Application No: BE/77/21/HH
Site Address: 19 South Way Bersted PO21 5HB
Description of works: Removal of 3 No existing lean-to structures & erection of single storey side & rear extensions, loft conversion to form new second floor with roof alterations to form gable end with rear dormer projection & detached outbuilding to be used as an annexe to the existing dwelling (resubmission following BE/37/21/HH).

Thank you for your internet representation made on 2nd June 2021 which has been recorded as an objection with the comments as follows:

PROPOSED DETACHED OUTBUILDING AT 19, SOUTH WAY, BOGNOR REGIS
FOR MR.O.SAPOZHNYK.

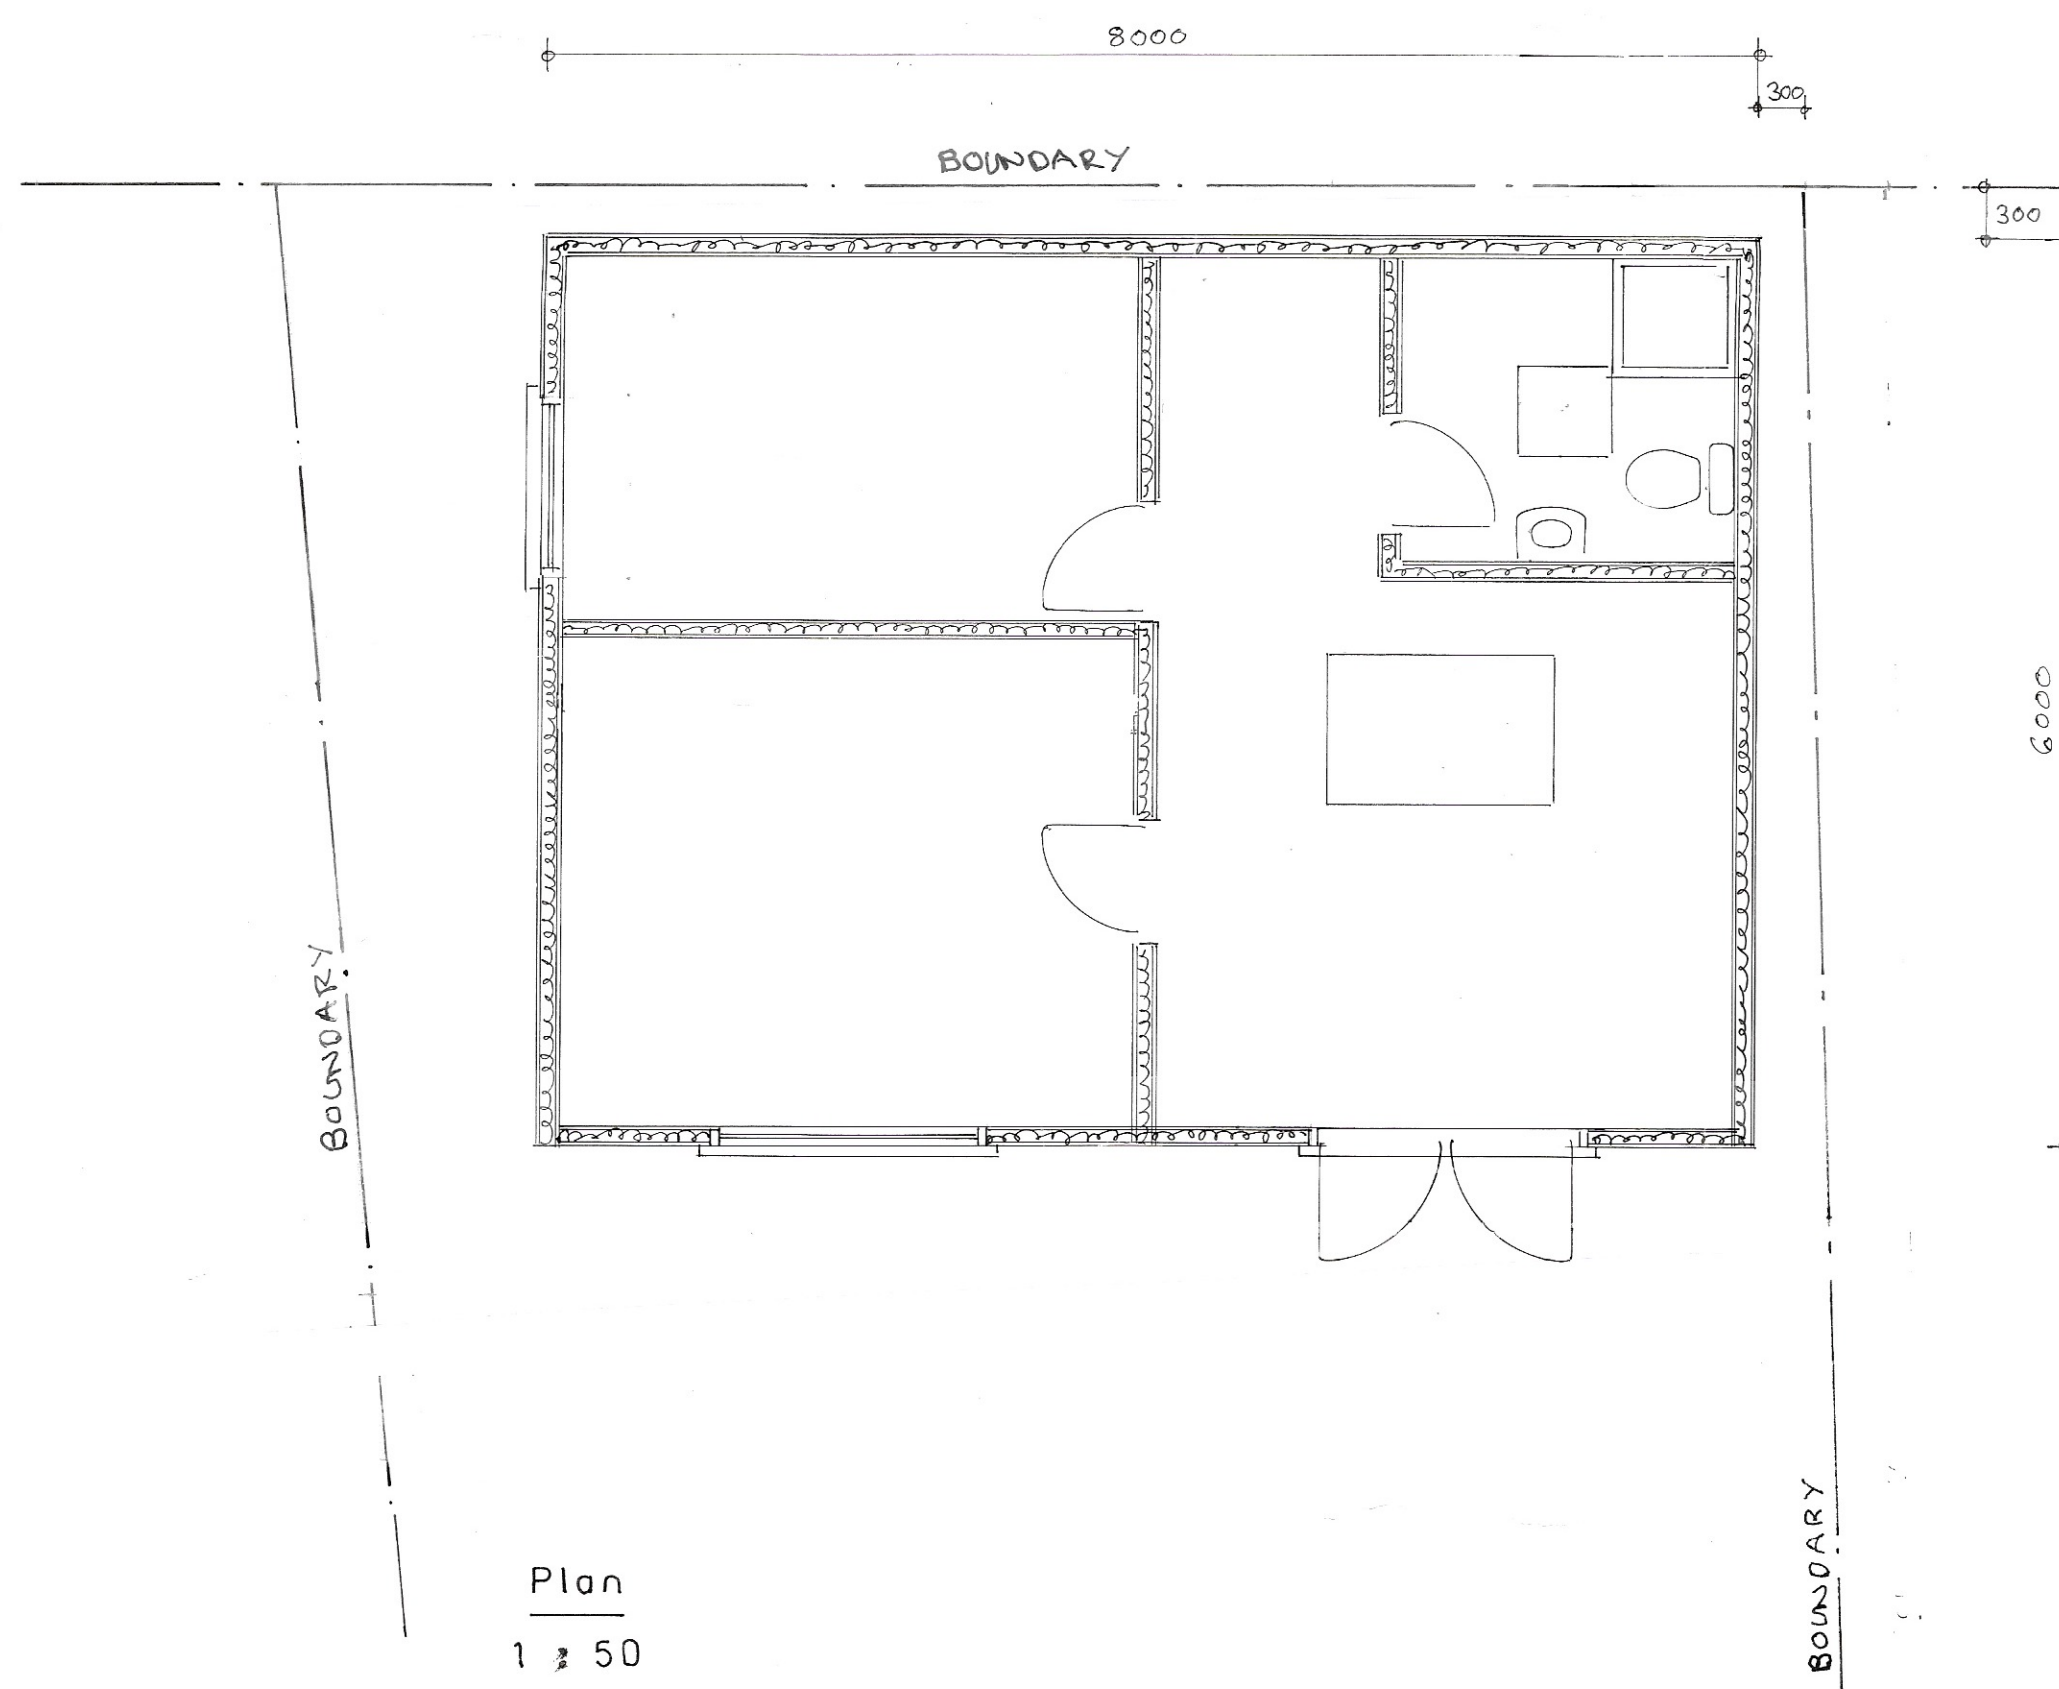
Rear Annex - Overbearing and unneighbourly effect for properties at 17 and 21 South Way contrary to Arun Local Plan policies D DM1 and D DM4.

The proposals appear to suggest this is a house of multiple occupation and should be considered as such by the planning authority, as this is out of character for the area.
